Name of Submitter	Woolloomooloo Finger Wharf Building Management Committee 6 Cowper Wharf Road, Woolloomooloo NSW 2011 “WFW” c/- McCormacks Strata Management Suite 5.01, Level 5, 151 Castlereagh St Sydney NSW 2000 samantha@mccormacks.com.au
Application Name	Art Gallery of NSW Expansion Project – Sydney Modern
Application Number	SSD 6471
Applicant	Art Gallery of NSW Trust
Council Area	City of Sydney
Approval Authority	Minister for Planning
Donation declaration	No reportable political donations in the last 2 years

Objection Statement

Woolloomooloo Finger Wharf Building Management Committee

14 December 2017

1 North Elevation
Scale: 1 : 250

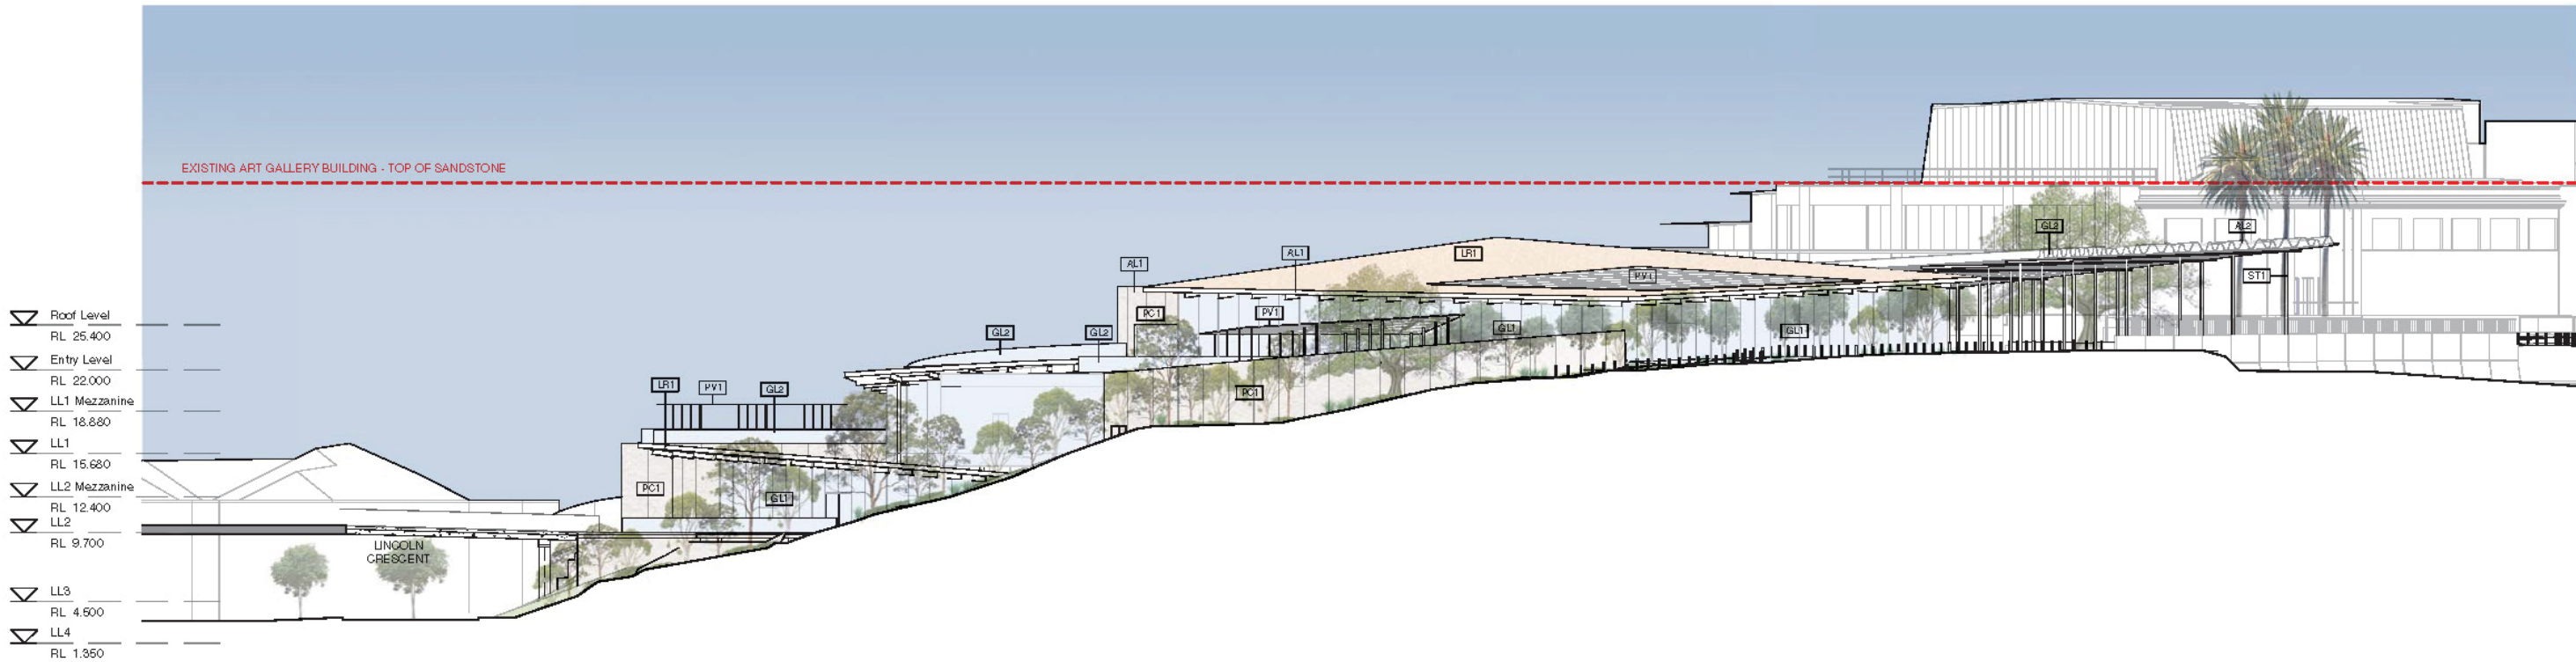
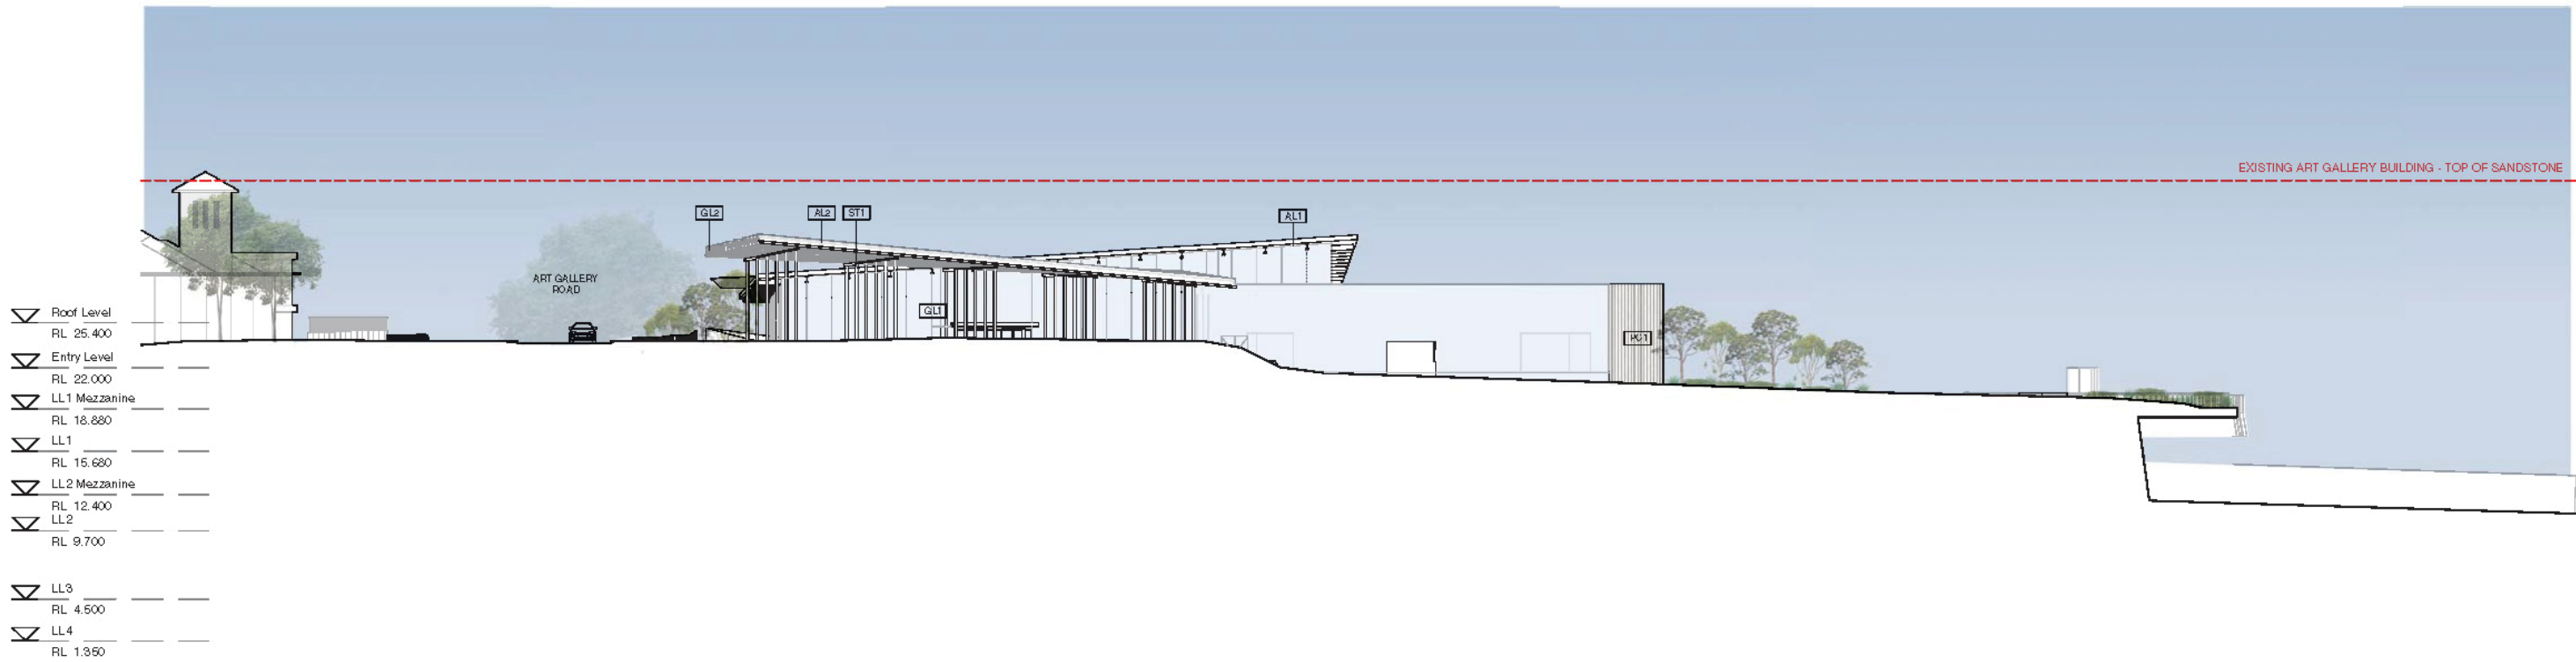
Comment - the view from WFW will be significantly altered. The design of the structures appears harsh, where some newspaper reports compare it to airport terminals. Additionally, there needs to be better use of recessive materials and colours, and judicious landscape planting. Further, consideration needs to be given to the landscaping where it is removing existing mature trees and also to soften the slabs of exposed walls. The tree report states there are 220 new plantings, but only minimal plantings to soften the 5 x 14 metre white wall.

Request - the Applicant needs to produce drawings or a montage of the landscaping to address these issues and mitigate the visual impact from WFW (diagrams to show different views from separate floor levels at WFW) - to be done in consultation with the main stakeholders including The Wharf Terraces.

Sheet Title
 Tree Significance

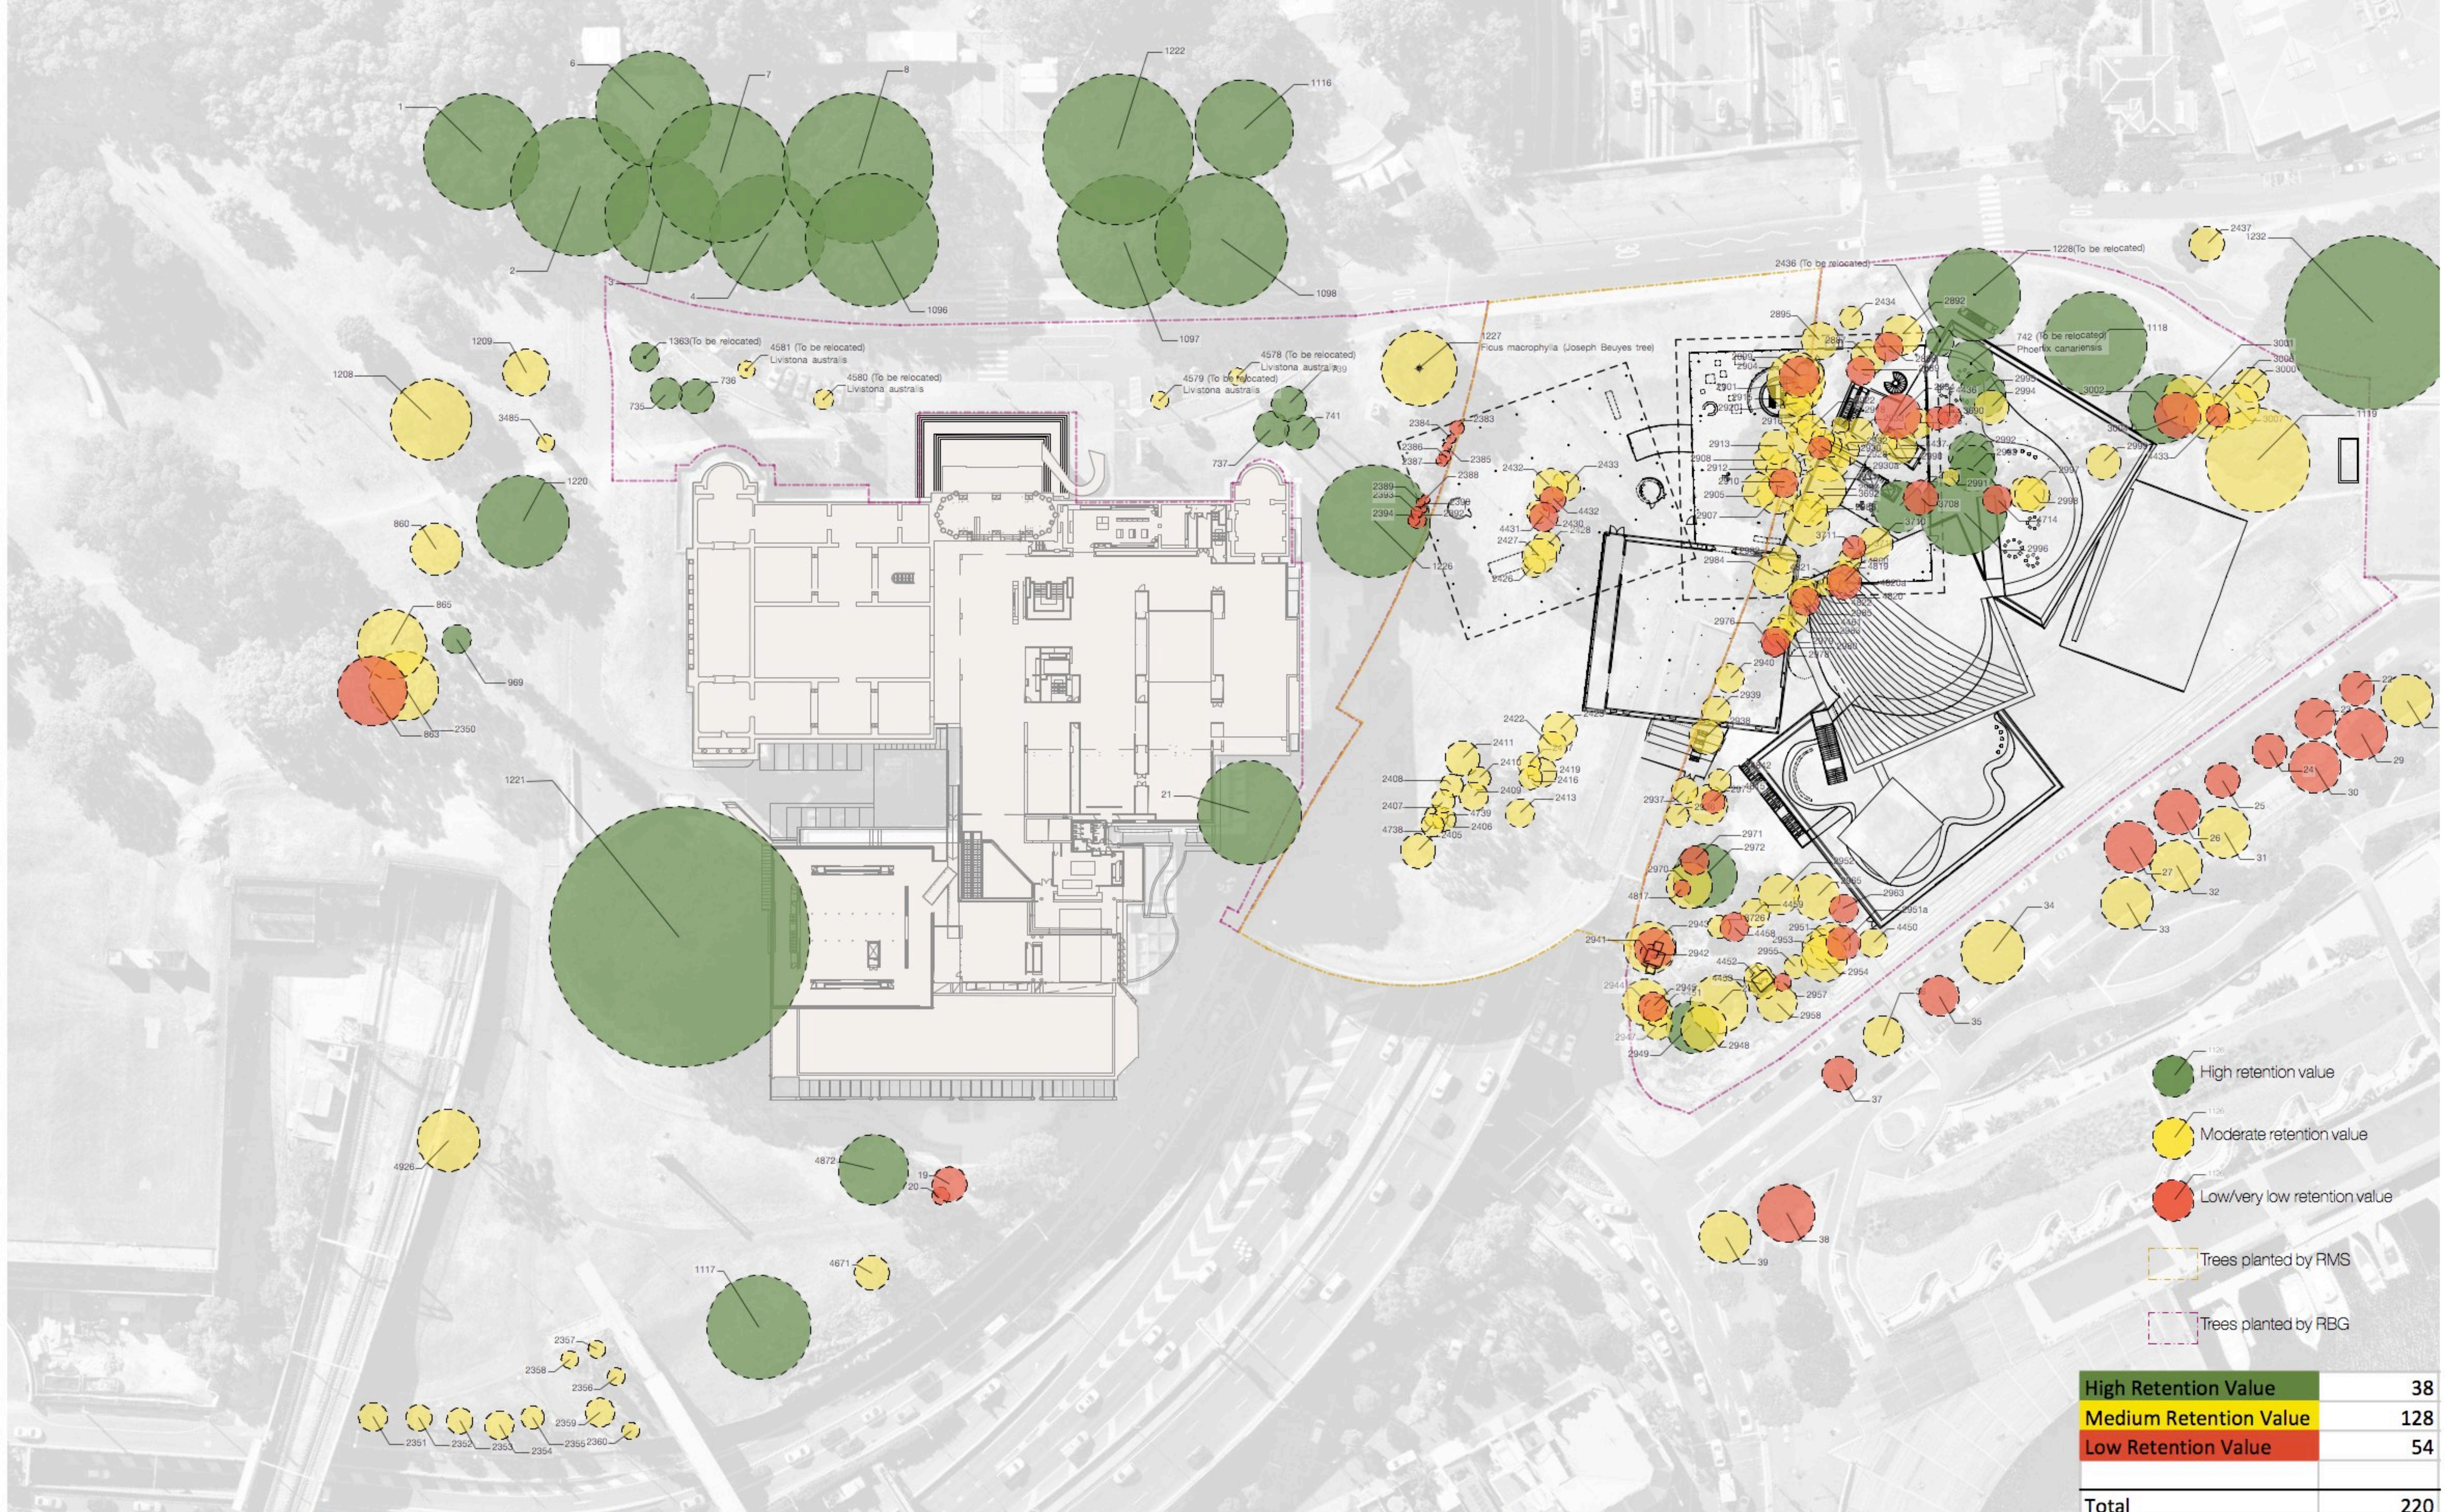
Request - further details are required to confirm that the SMP complies with the Botanic Gardens and Domain Trust and Act, particularly when considering the cutting of mature trees, the use of the land that is currently being used as open space by the public.
